Re: Minor Modifications to Proposed New Build Dwelling.

At: Plot 3, "The Old Smithy", 64 Hoyland Road, Hoyland Common, Barnsley.

Approval No: 2008 / 0653. Approval Date: 12th. June 2008.

PROJECT	Type A Dwelling	
CLIENT	Mr. & Mrs. A. Turner	
TITLE	Elevations & Layouts	
ADDRESS	land adj. "The Old Smithy", Hoyland Rd, Hoyland Common	
DRAWN BY	ggg	
SCALE	1:100; 1:50	DATE Apr. 08
DRAWING No	670-03	REV. 0

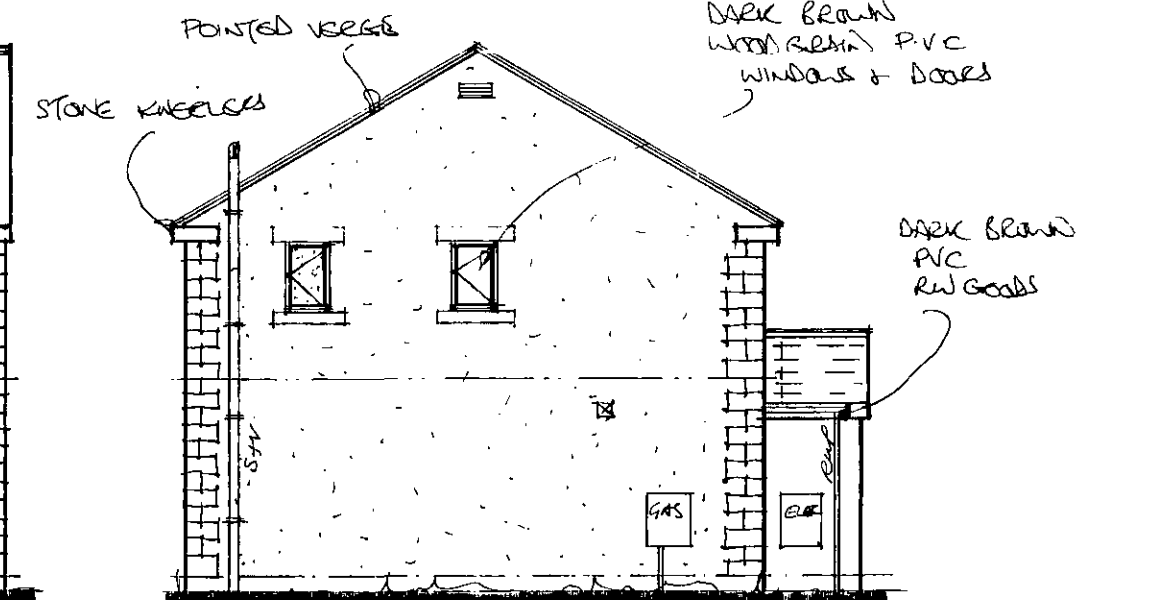
The alterations are simply the introduction of an additional 1.00m wide window to the first floor front elevation and re-location of the existing window (to match up with ground floor windows), and as you can see, this would not be a detrimental alteration to the front elevation.
